Environmental Assessment Report - Executive Summary

This Environmental Assessment Report (EAR) is submitted to the Minister for Planning pursuant to Section 75W of the Environmental Planning and Assessment Act 1979 (EP&A Act). Specifically this application seeks to modify Project Approval 10_0010 to account for minor external changes to the approved Dick Smith building.

Dick Smith Warehouse Facility and associated infrastructure - MP10 0010

TITLE
**GATEHOUSE
PLANS AND ELEVATIONS**

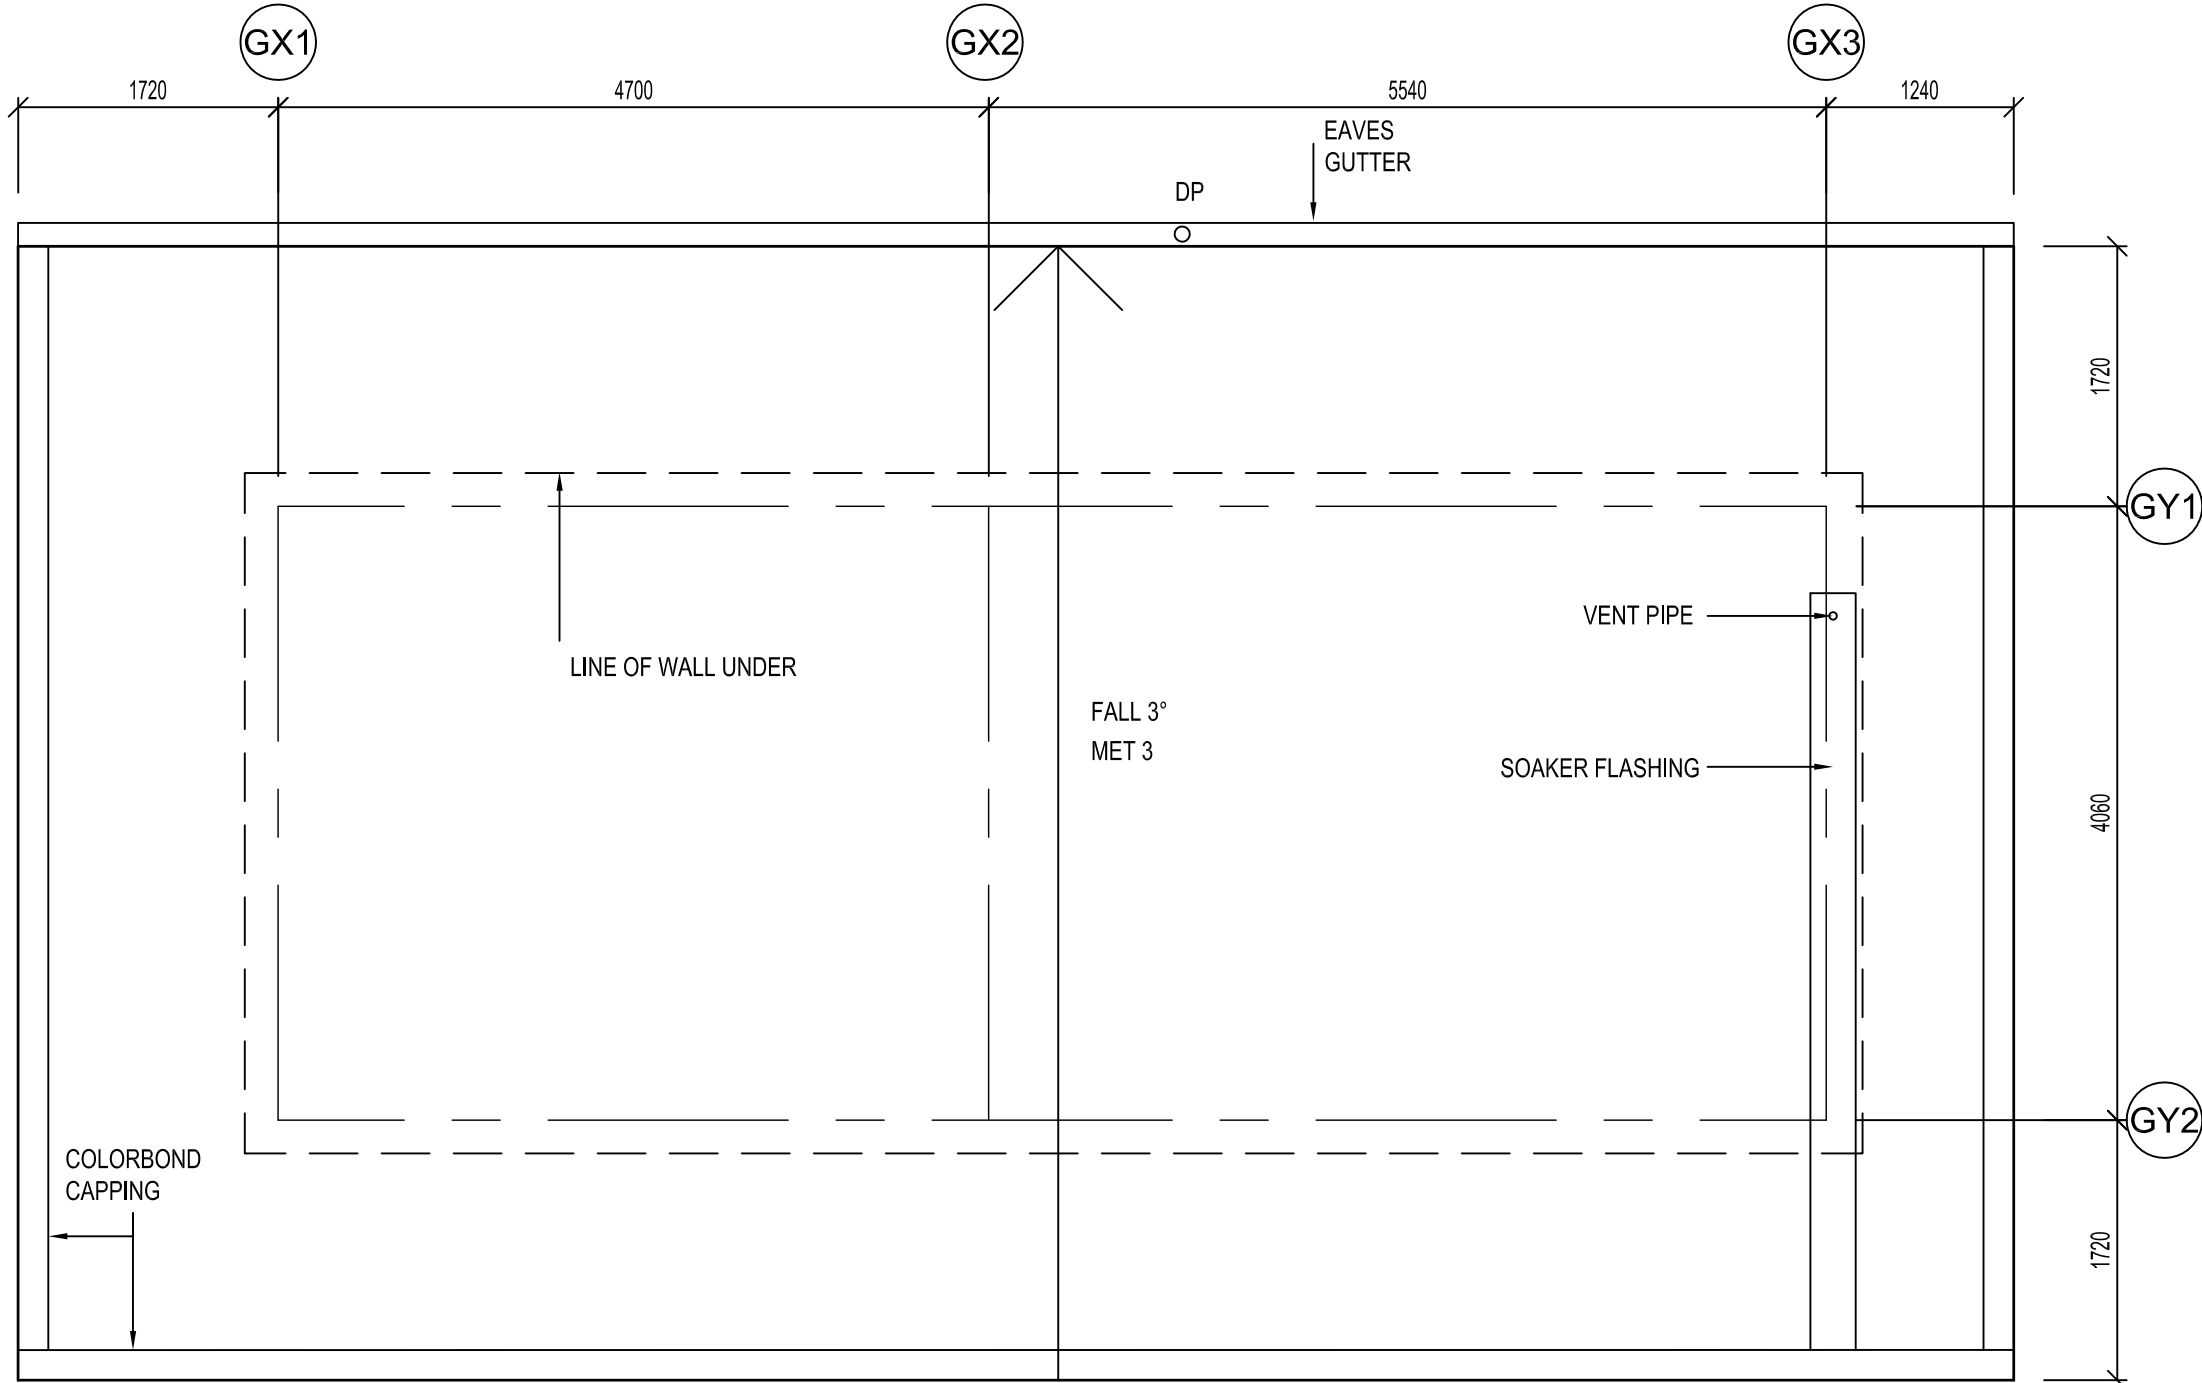
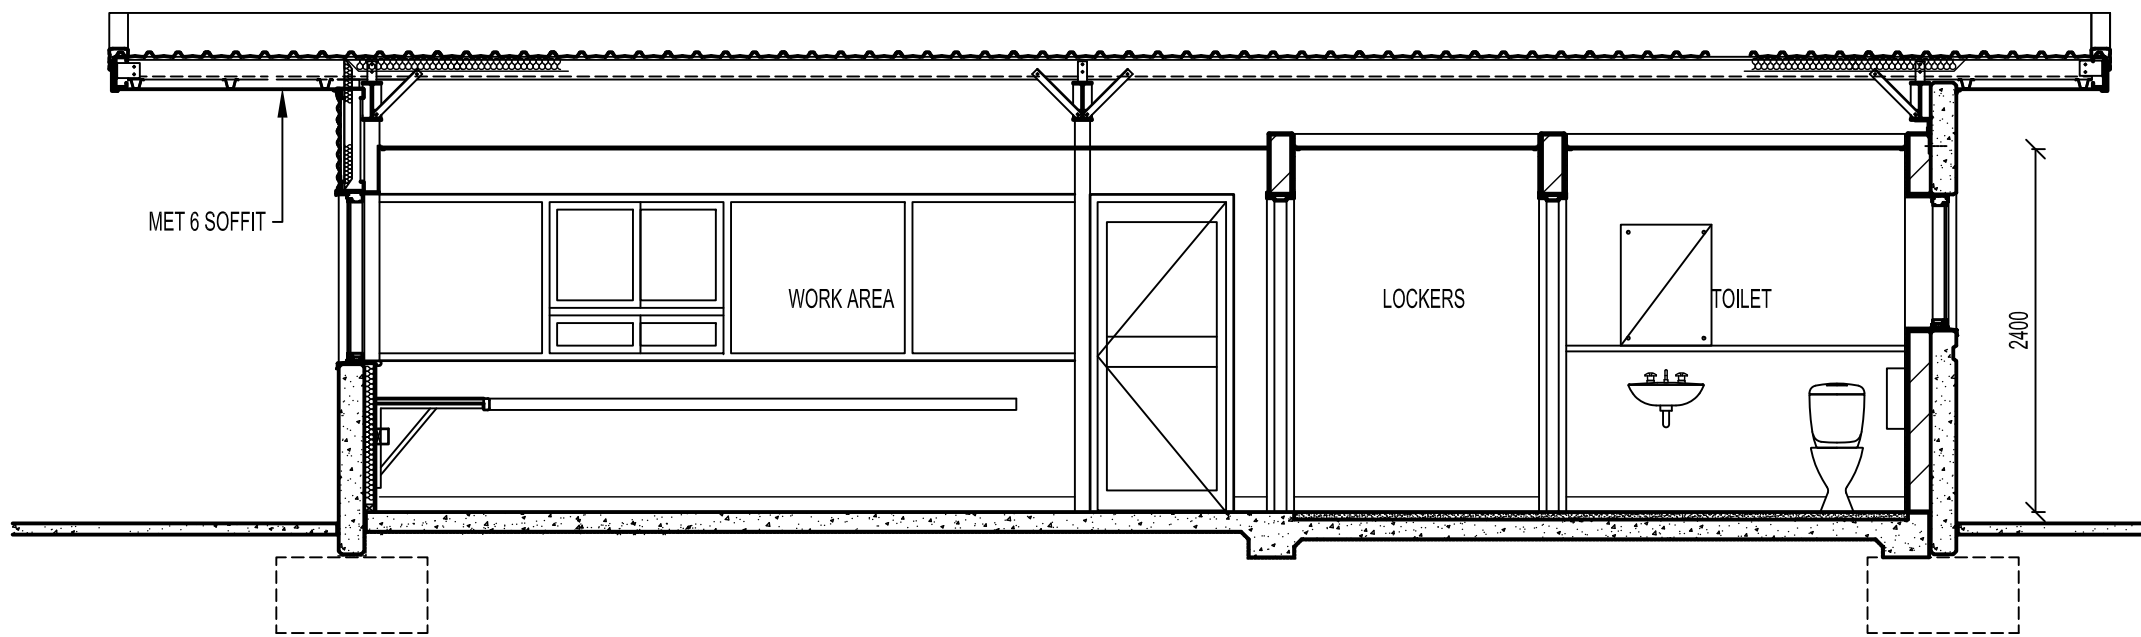
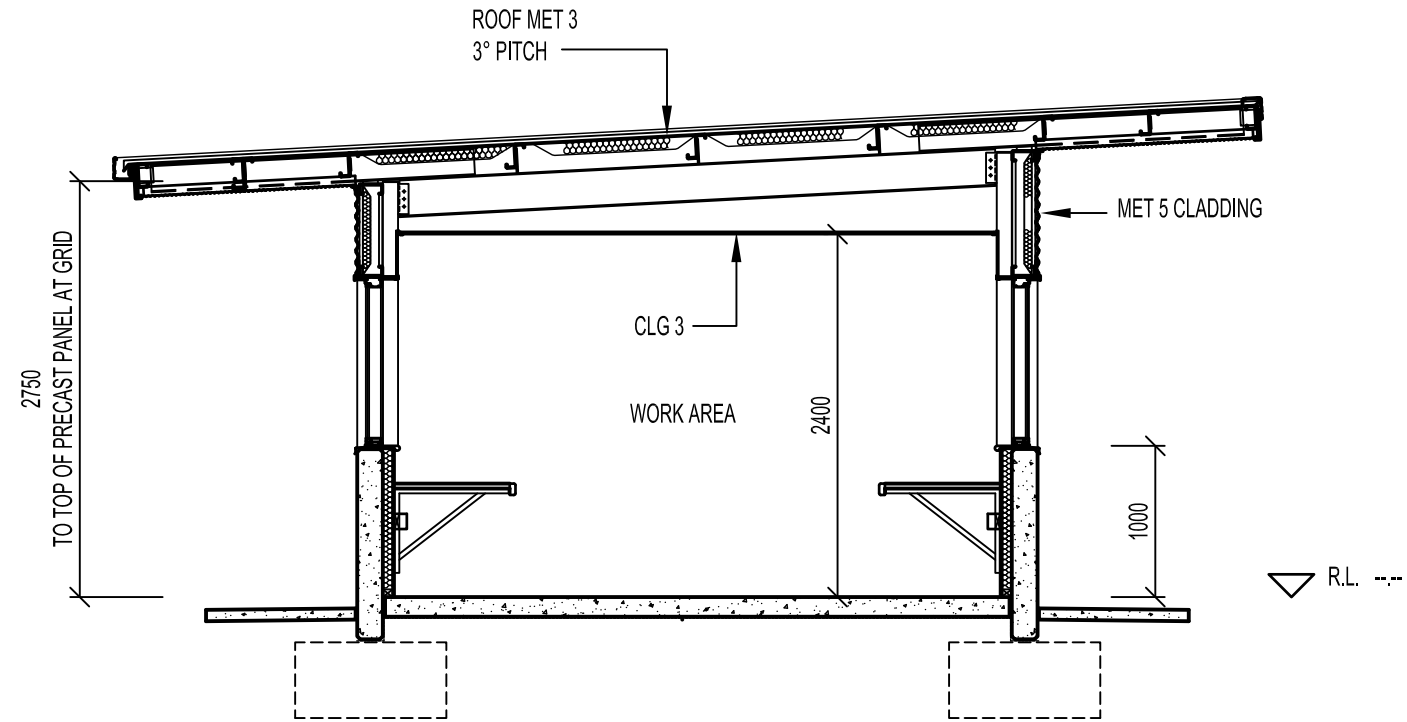
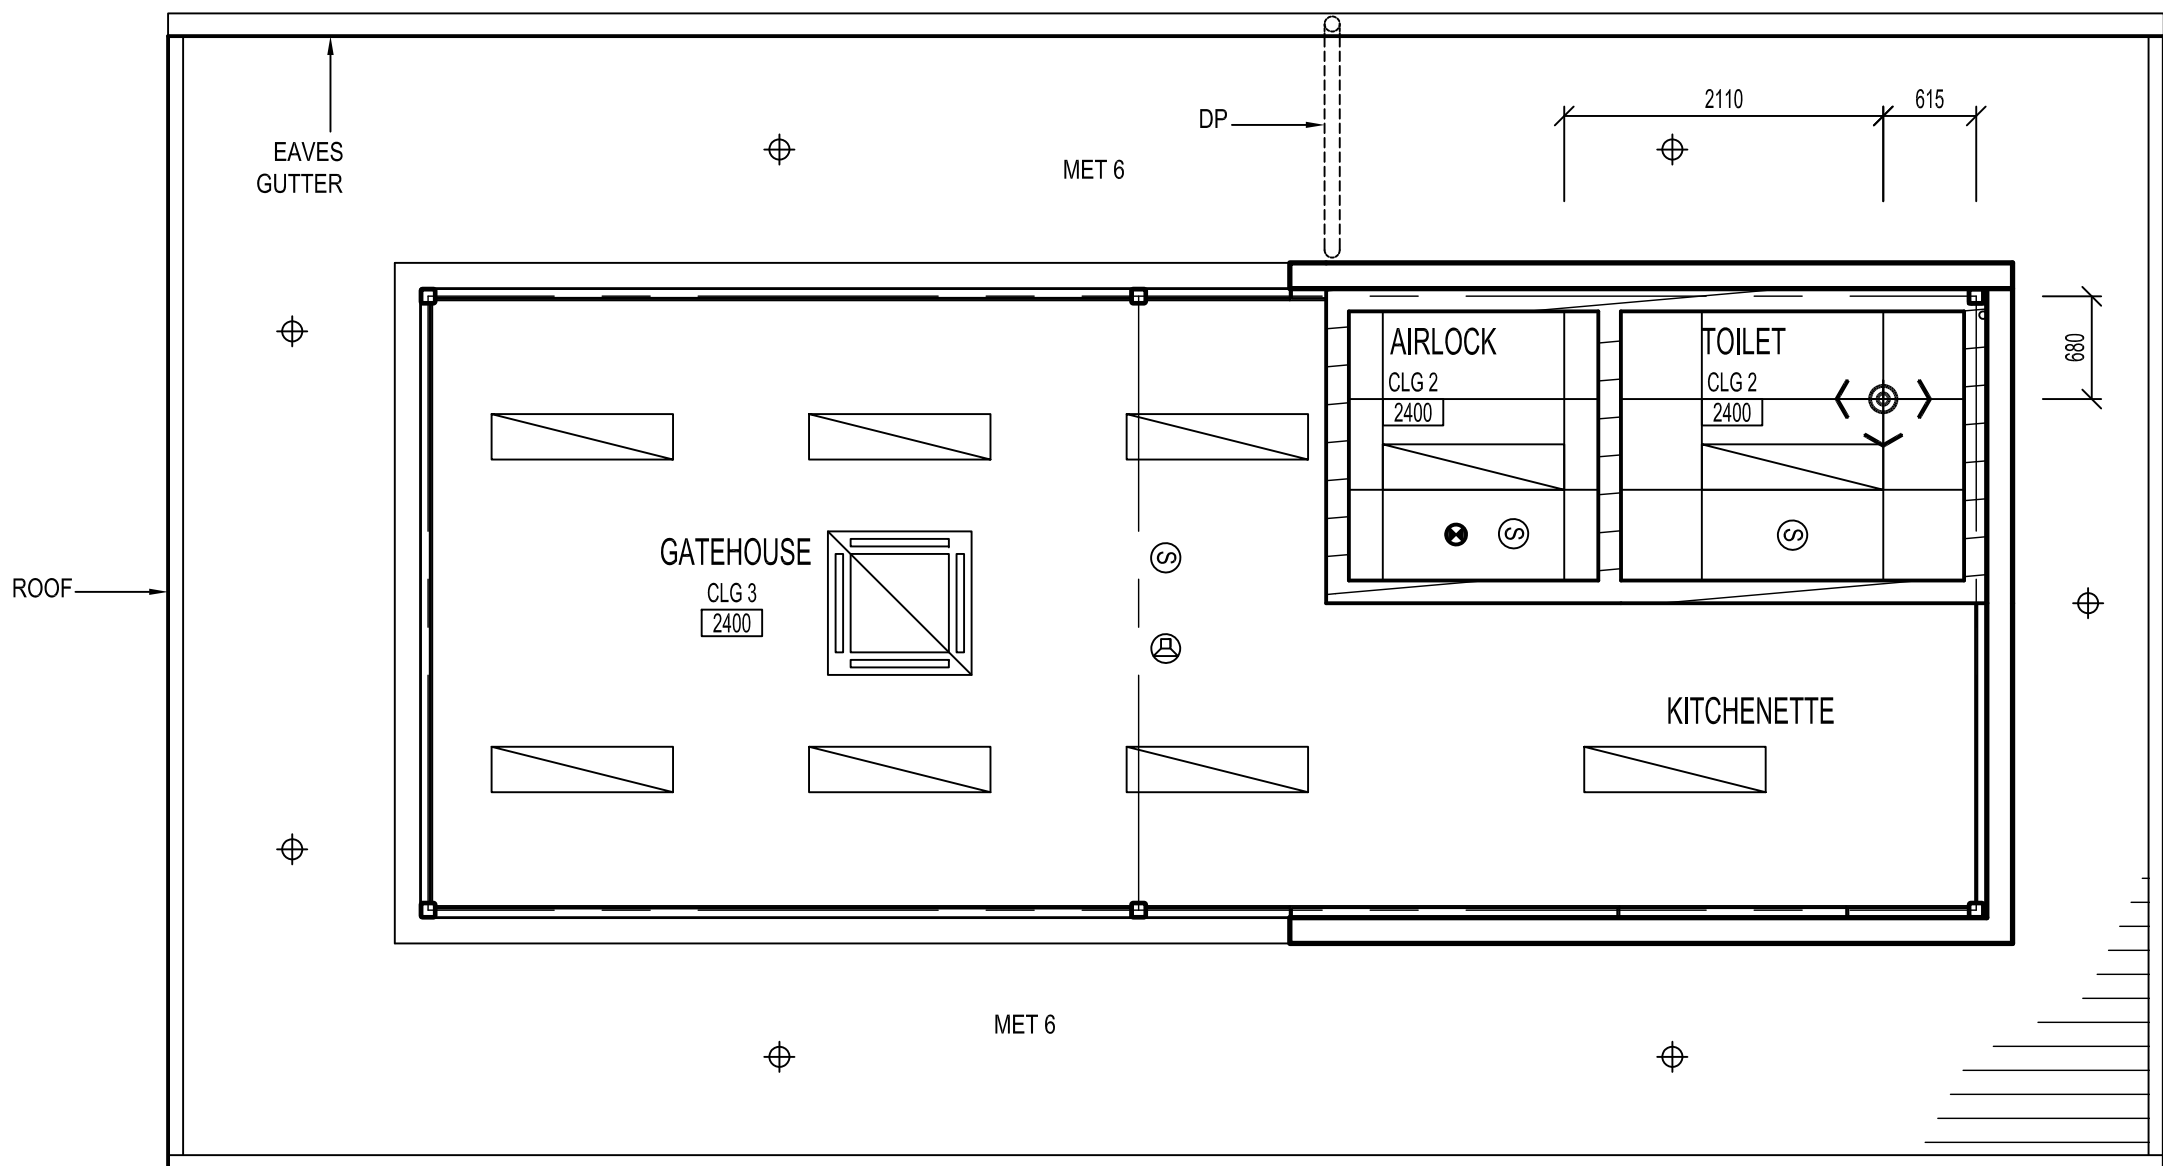
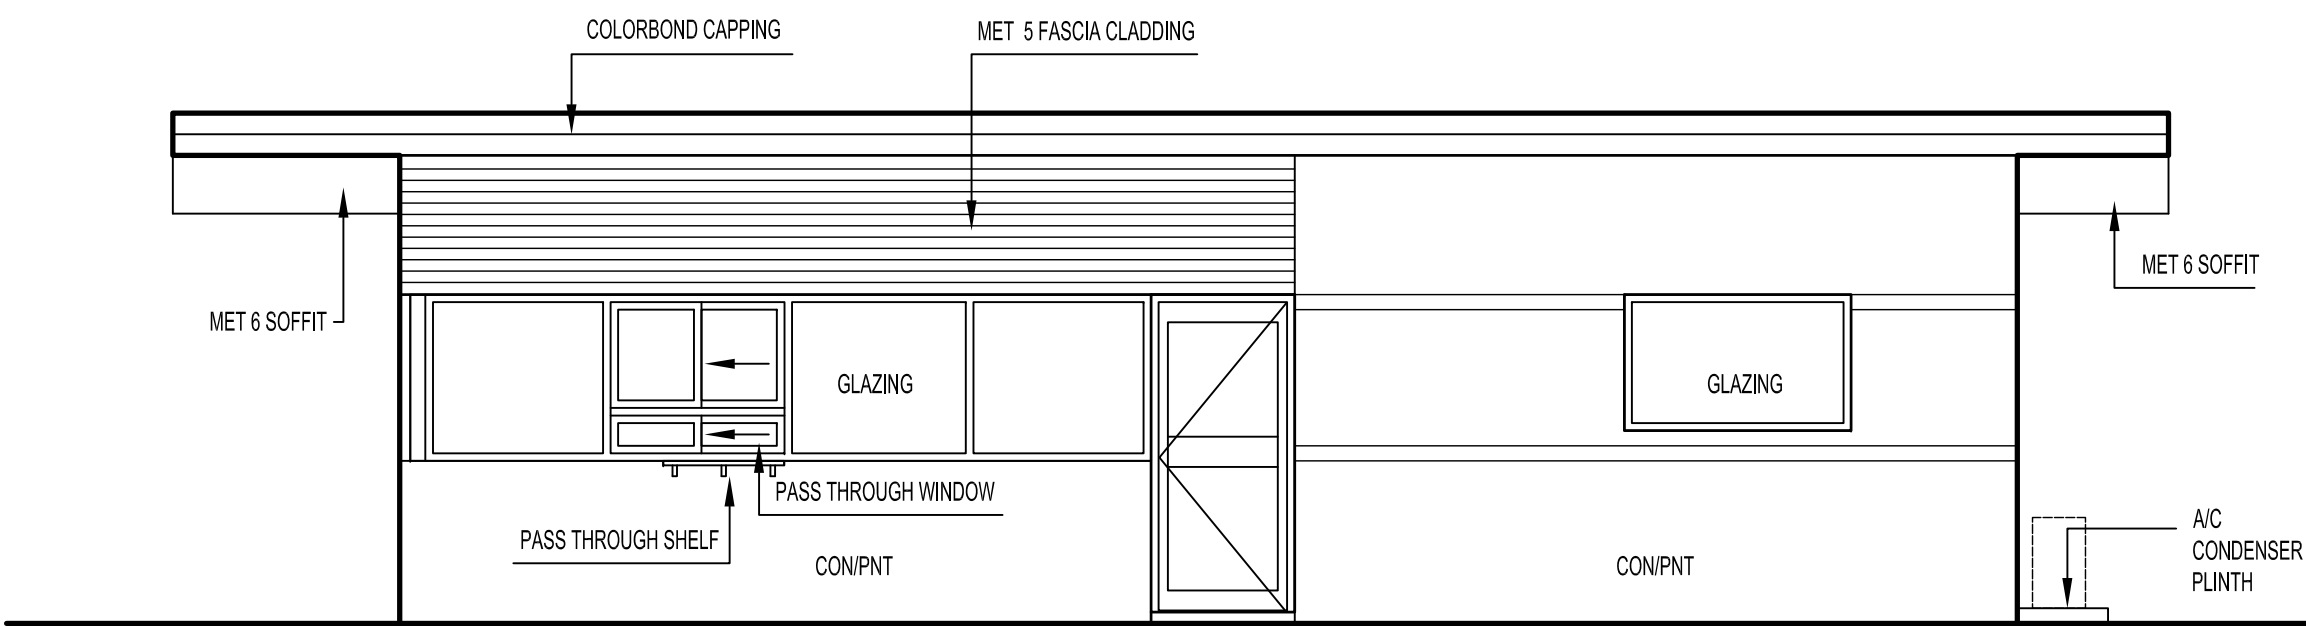
| No. | Item | Description |
|-----|-------------------------------------|---------------------------------------------------------------------------------------------------------------------------------------------------------------------------------------------------|
| 1 | Addition of a gatehouse | New item introduced for security purposes. |
